**KIRKLEES METROPOLITAN COUNCIL
INVESTMENT & REGENERATION SERVICE**

DELEGATED DECISION TO DETERMINE PLANNING APPLICATIONS

Reference No:	2023/62/91260/E
Site Address:	444A, Huddersfield Road, Ravensthorpe, Dewsbury, WF13 3EP
Description:	Erection of two storey rear extension to existing commercial premises, raising of roof height and erection of front and rear dormers and alterations to form 8 unit HMO
Recommending Officer:	Nina Sayers

Officer Report

PROPOSED: GA PLANS	SCALE: 1:50
-----------------------	----------------

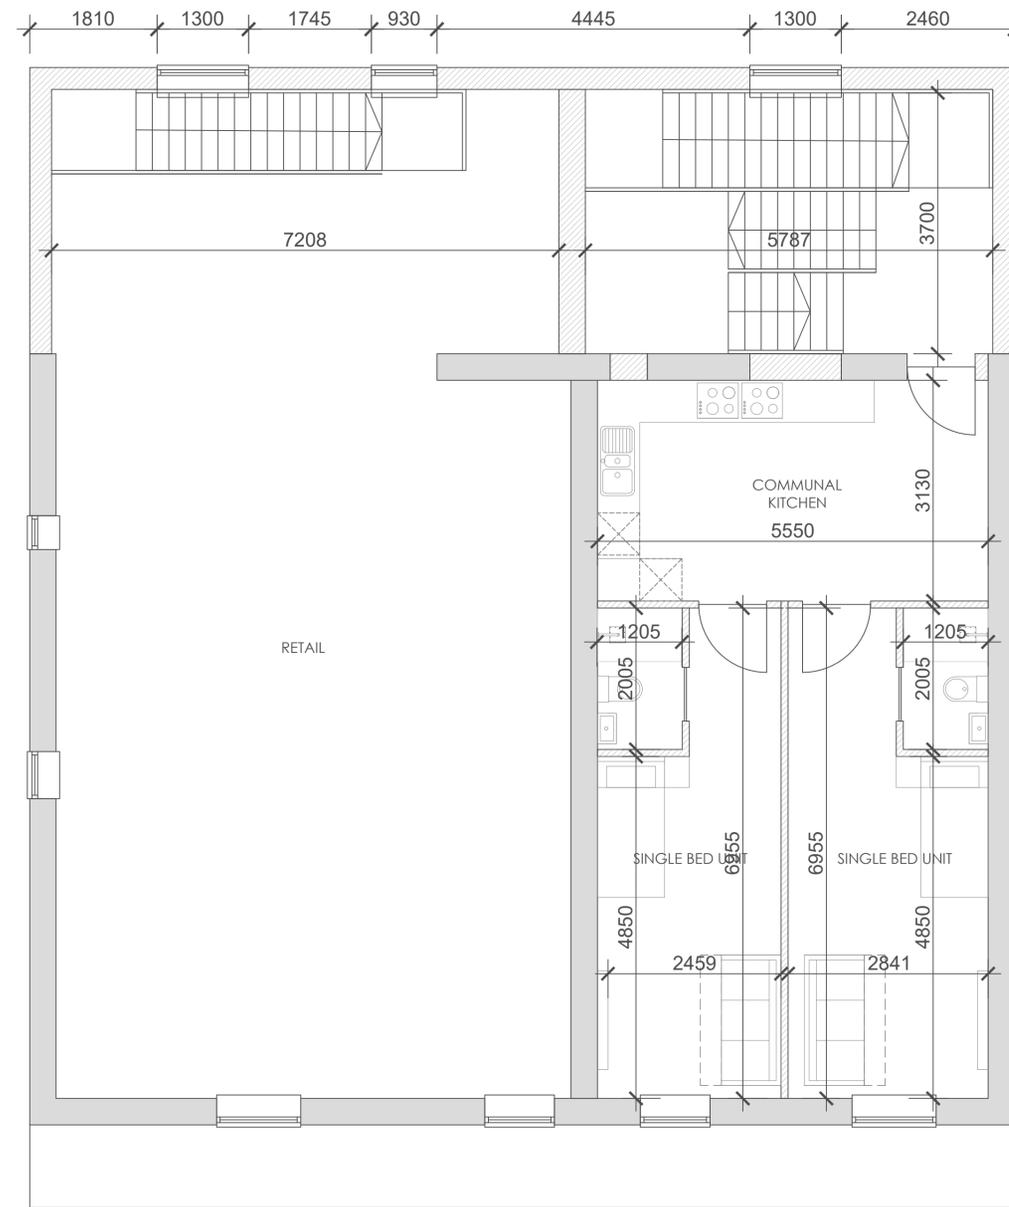
Officers had concerns regarding the design of the roof. It was requested that this was set down to be more in keeping with the existing buildings and a street scene provided to show the relationship with the adjacent building. Officer also asked that openings were put into the communal kitchen space. Amended plans were sought and received.

PROPOSED:
 ELEVATIONS

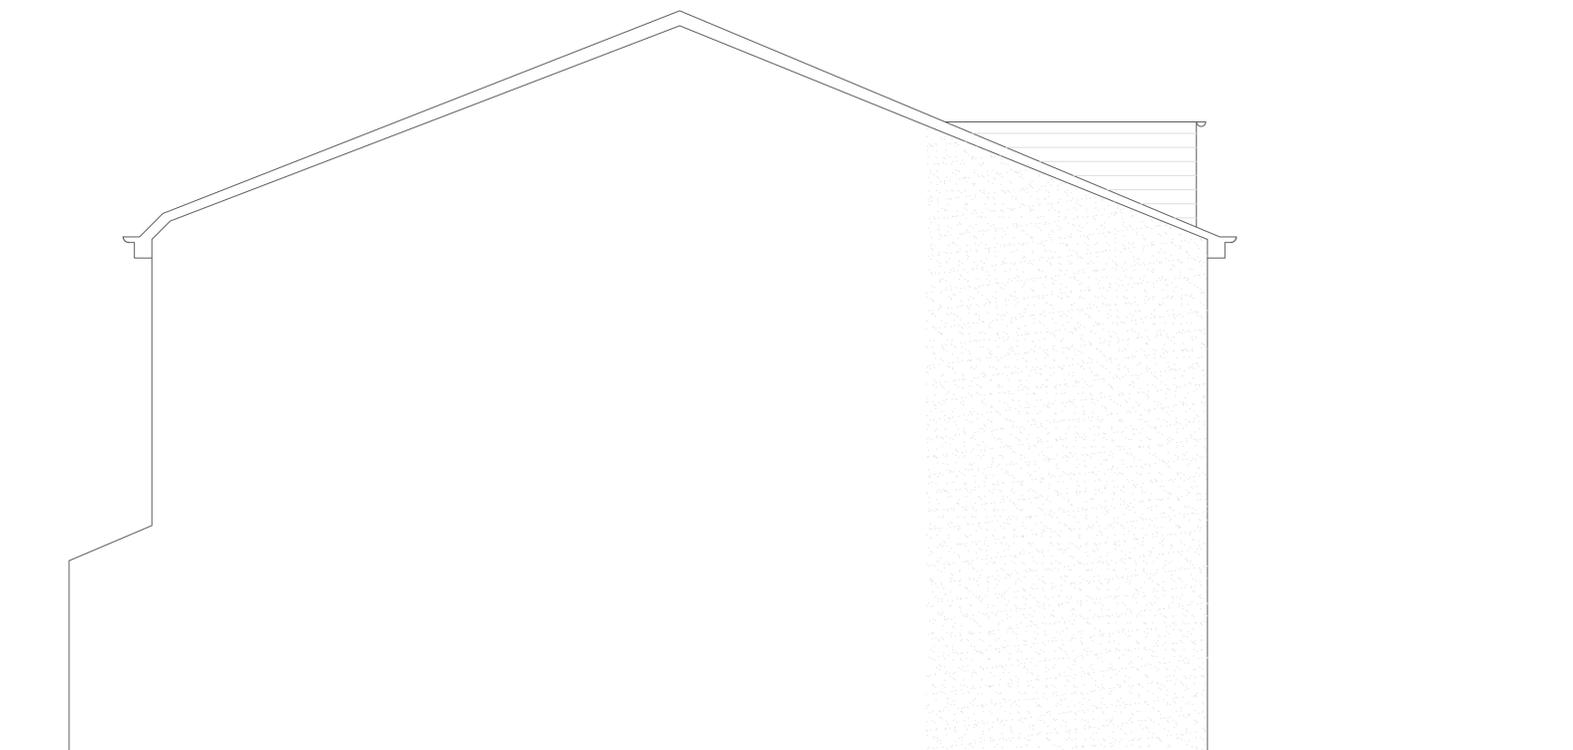
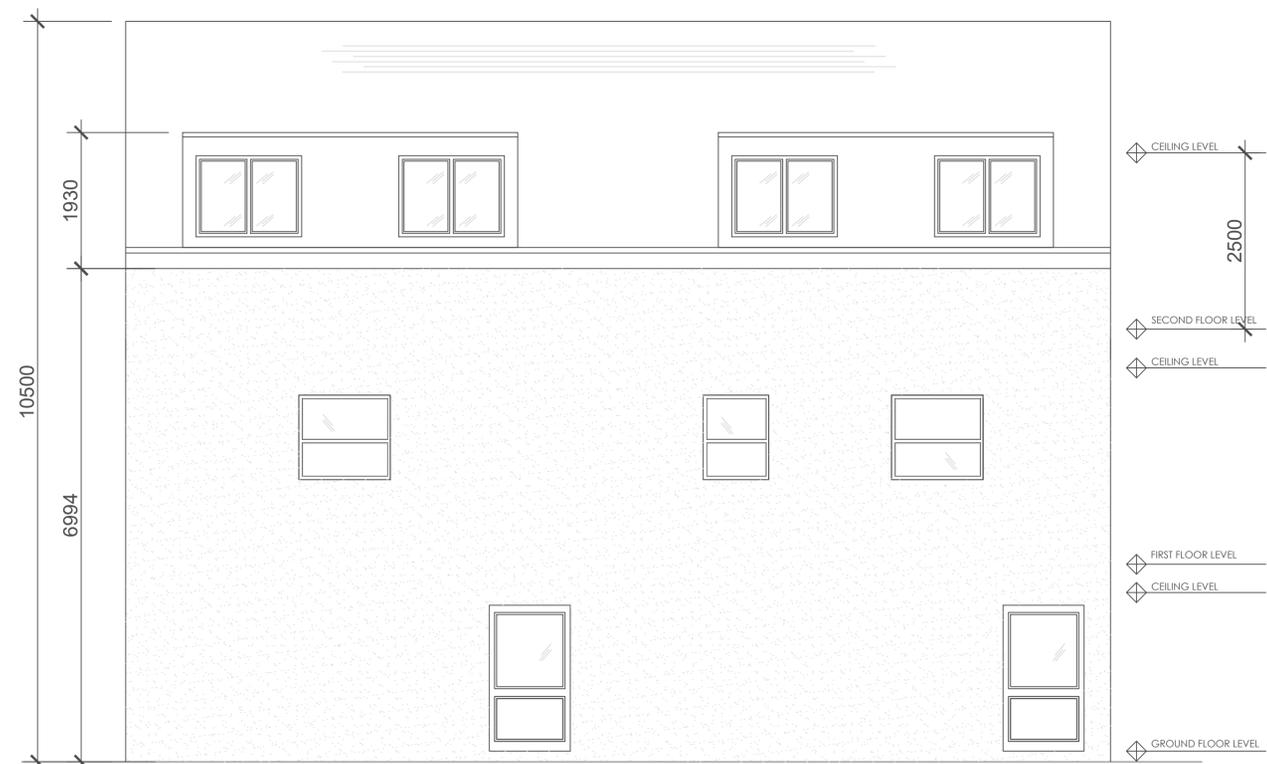
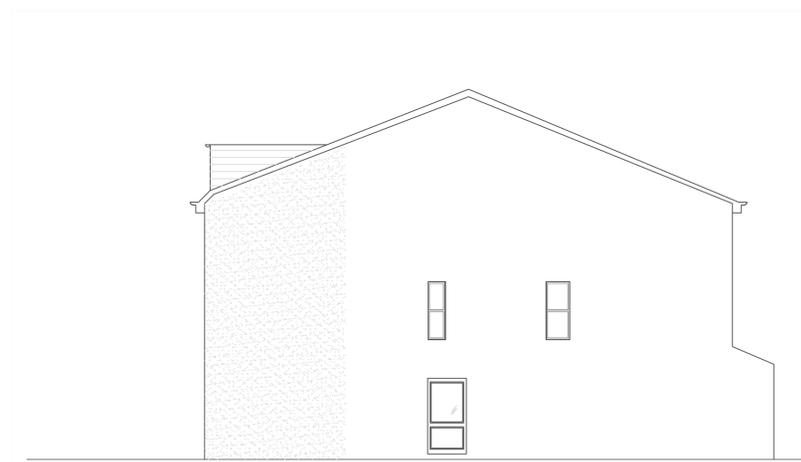
The proposed development would increase the height of the building and change the roof type from hipped to pitched. It is noted that within the street scene, the properties vary in terms of design and roof height. The proposed development would be similar in character to, and would not protrude above the roof ridgeline of, the existing, adjacent building. Therefore, the proposed building is considered to not cause any harm to visual amenity of the wider street scene, over and above the existing arrangements on site. It is noted that the dormers have been removed from the front elevation of the proposal, although this was not requested by officers.

area in terms of design. The rear elevation would be finished in sandstone render which is considered to be in keeping with surrounding built development. Other properties in the immediate vicinity also have rear dormers of a similar scale and design and the proposed dormers would be set within the roof face. Therefore, no significant harm is considered to be caused to visual amenity.

Whilst the proposal would result in the proportions of the front elevation being altered with respect to the distance between the window openings and eaves, as noted above, there is no distinct character within the street scene and as such, this arrangement would not significantly detract from visual amenity.
